Our Ref: LU/87/18/HH
Your Ref:

Town & Country Planning Act 1990 (as amended)
Town & country Planning (Development Management Procedure) (England) Order 2015
Application for Planning Permission for Works or Extension to a Dwelling

Development Single storey rear extension with lantern
Location 57 Hollist Chase Wick Littlehampton

BLOCK 1:500

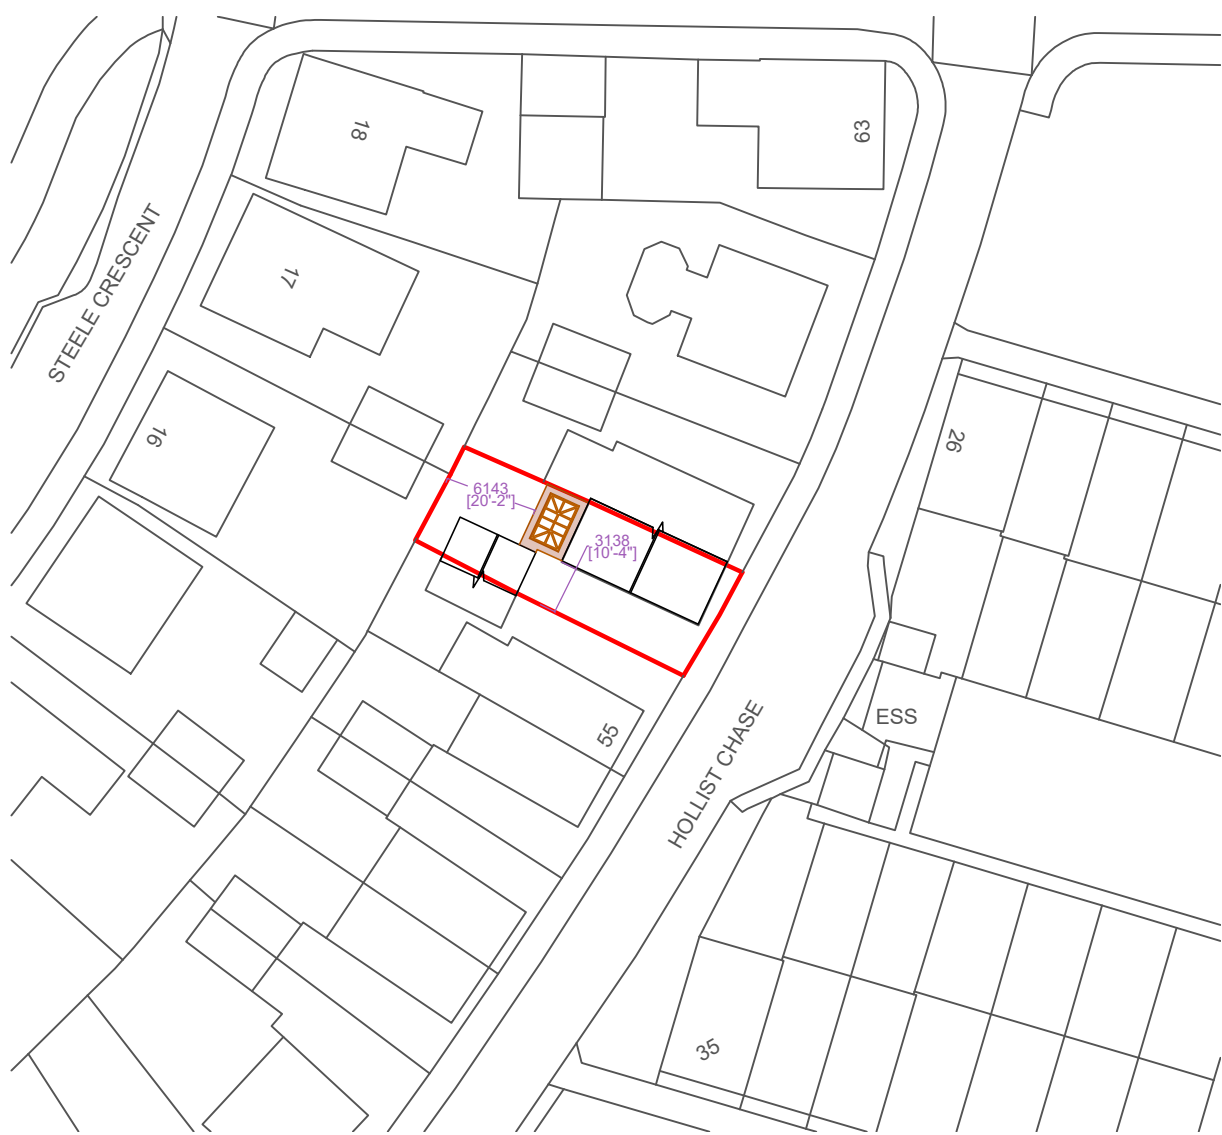
Block Plan

Please submit 1 electronic or 3 paper copies of an amended block/site plan at a scale of 1:500 or 1:200 showing the measurements (in metric) to the boundaries
